Your Ref: planning application P/58/19/PL

With respect to the above planning application we make the following observations.

The access to the Inglenook Hotel car park and the proposed development of 9 dwellings at the rear is not fit for purpose, given that;

Drawing Title
Refuse Vehicle Access and Egress
and Concurrent Car's Movements

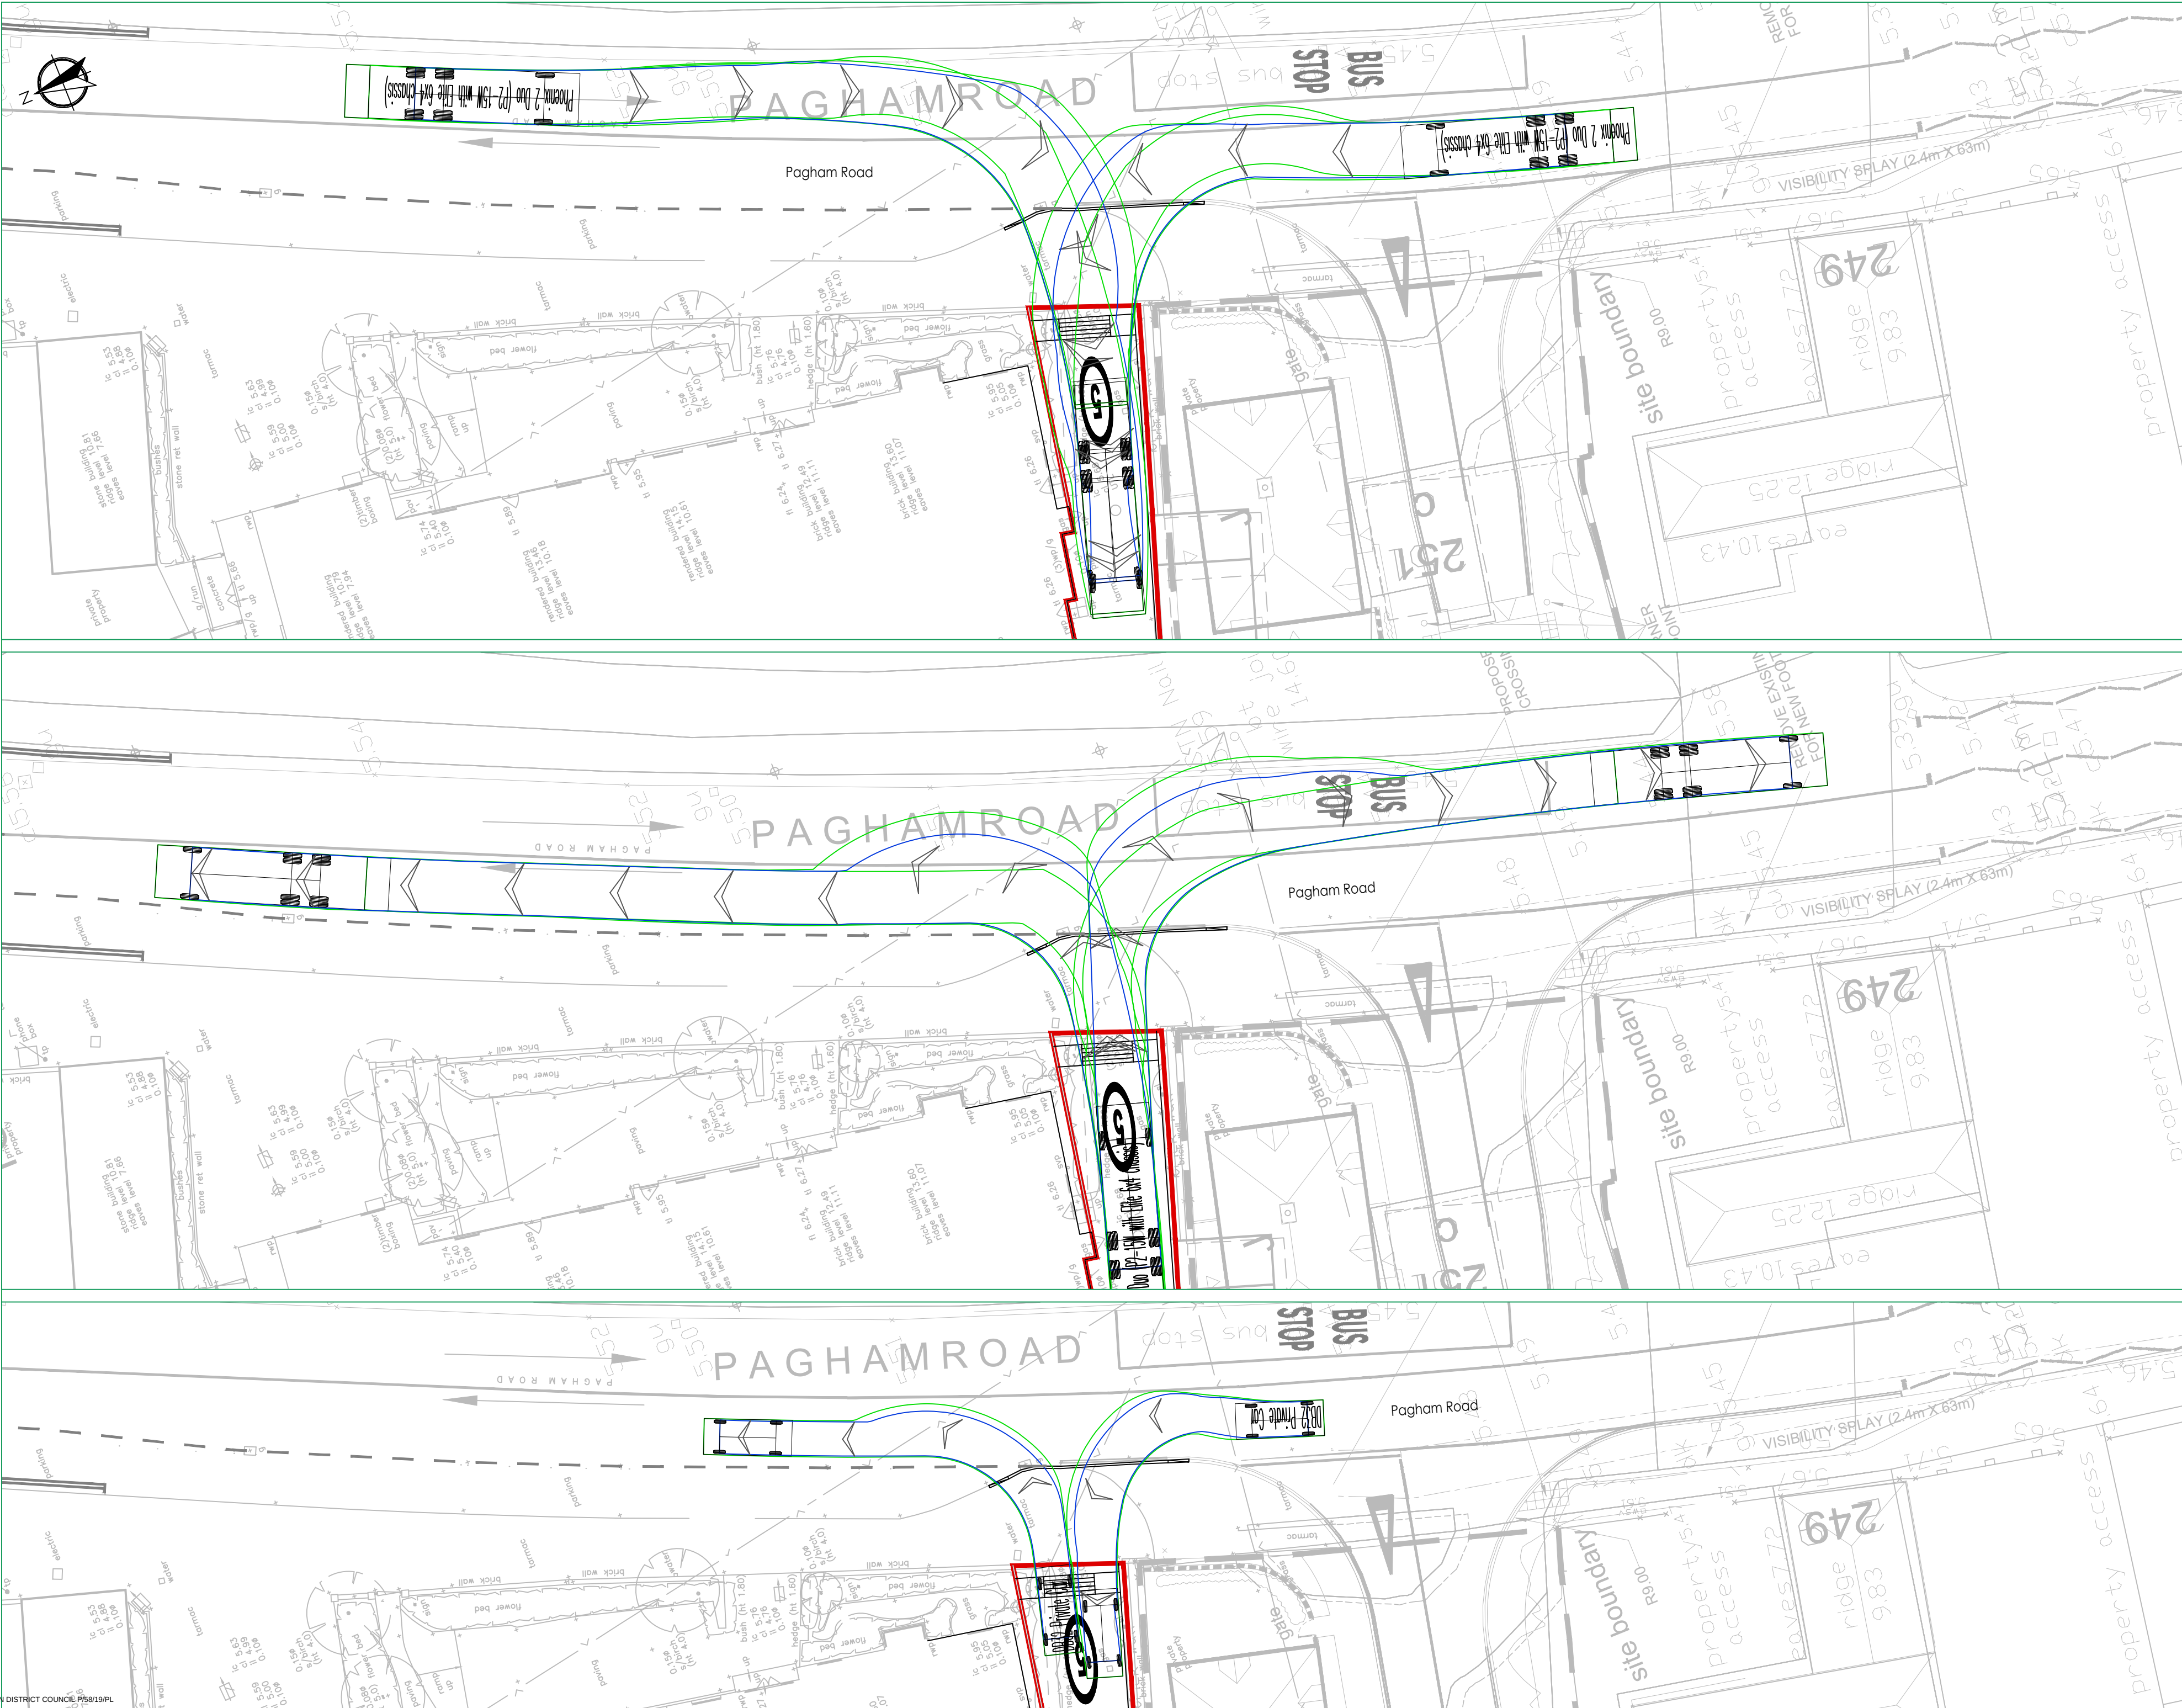
Even after demolishing the storage area on the south wall the access road is not wide enough for vehicles to pass.

With nine dwellings it is not unreasonable to assume 2 cars per dwelling, also 2 children per dwelling, also taking into account the visitors to the hotel there are going to be at least 100 movements a day. The entrance at Pagham Road is not suitable for vehicles to wait while other vehicles exit. This will cause danger to both pedestrians and vehicle traffic on Pagham Road.
